Rezoning Transportation Analysis

Petition Number: 2022-174

Date	Description
2-22-23	First Review (IW)
03-22-23	Second Review (IW)
04-25-23	Third Review ZC (IW)

SITE PLAN SCALE 1:20

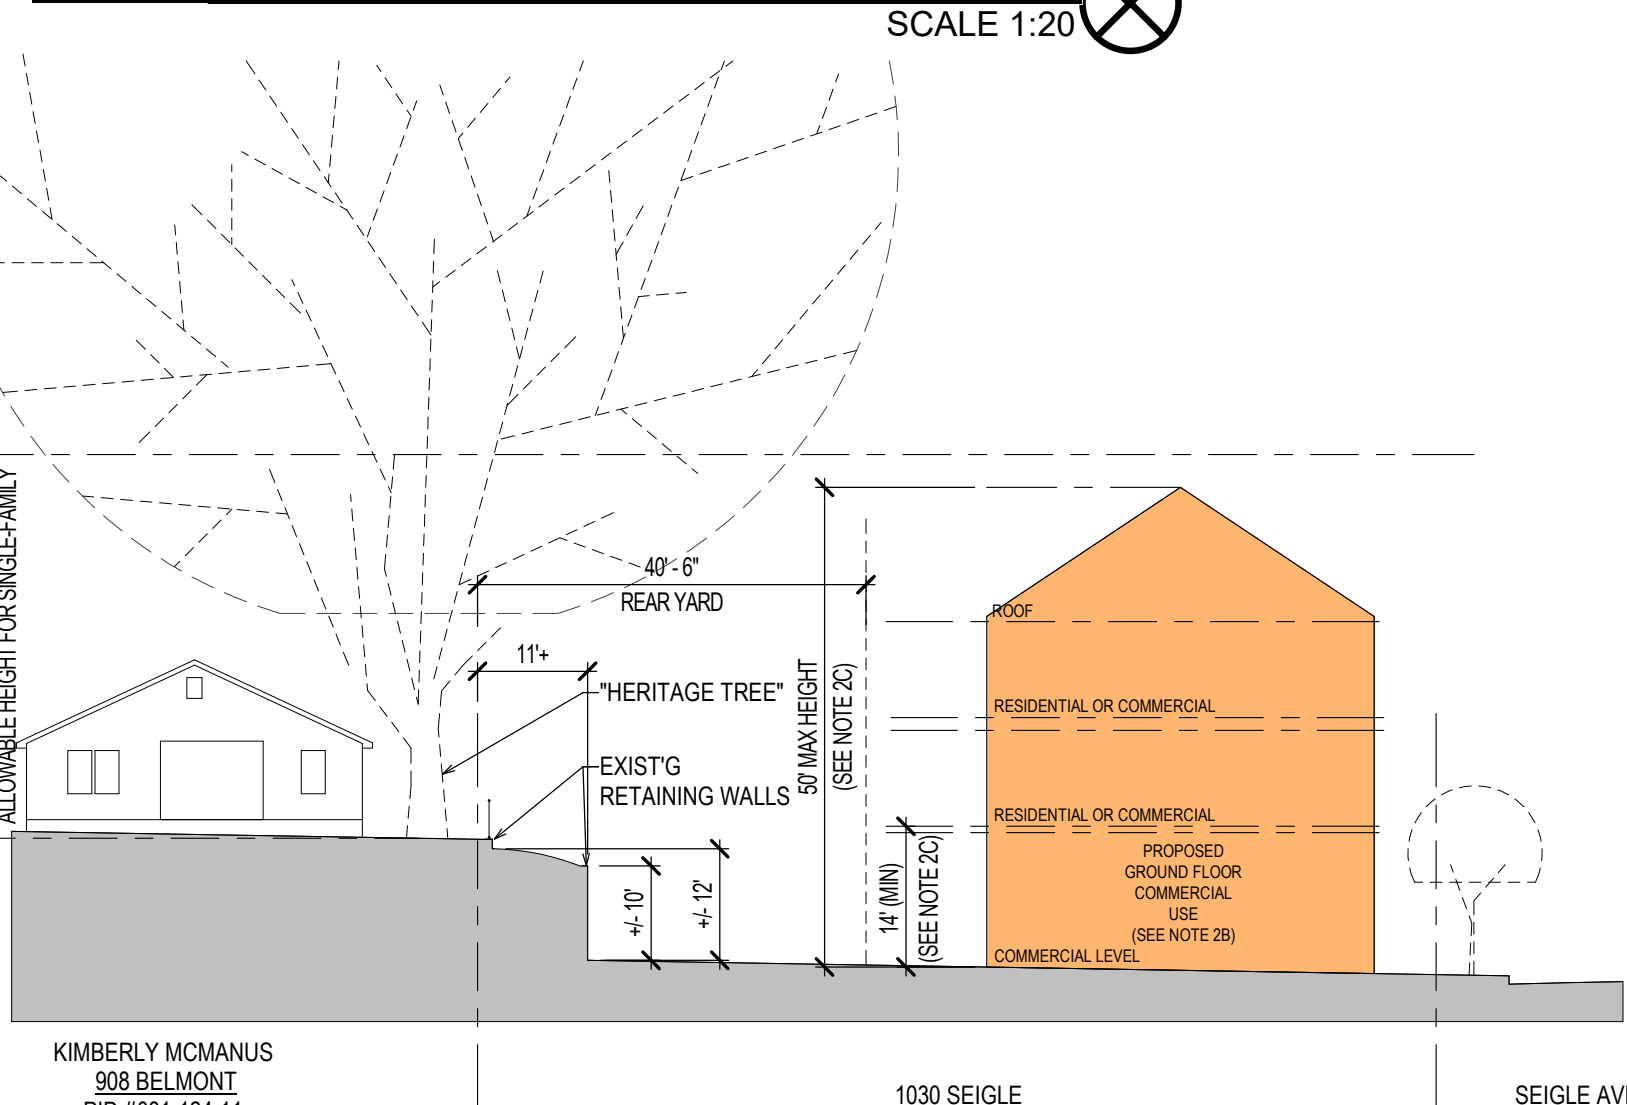
~~Clarifying Comment from 03-22-23~~ Existing curb and gutter can remain in existing location but label and dimension the future curb and gutter location from the centerline for each road on the site plan.

~~Clarifying Comment from 03-22-23:~~ Site plan shows 25' to centerline but does not show the existing 50' from centerline. Label and dimension the existing 50' right of way from centerline of road.

~~Clarifying Comment from 03-22-23: CDOT REQUESTS petitioner commit to 8' sidewalk and place Streets Map streetscape behind future curb location.~~
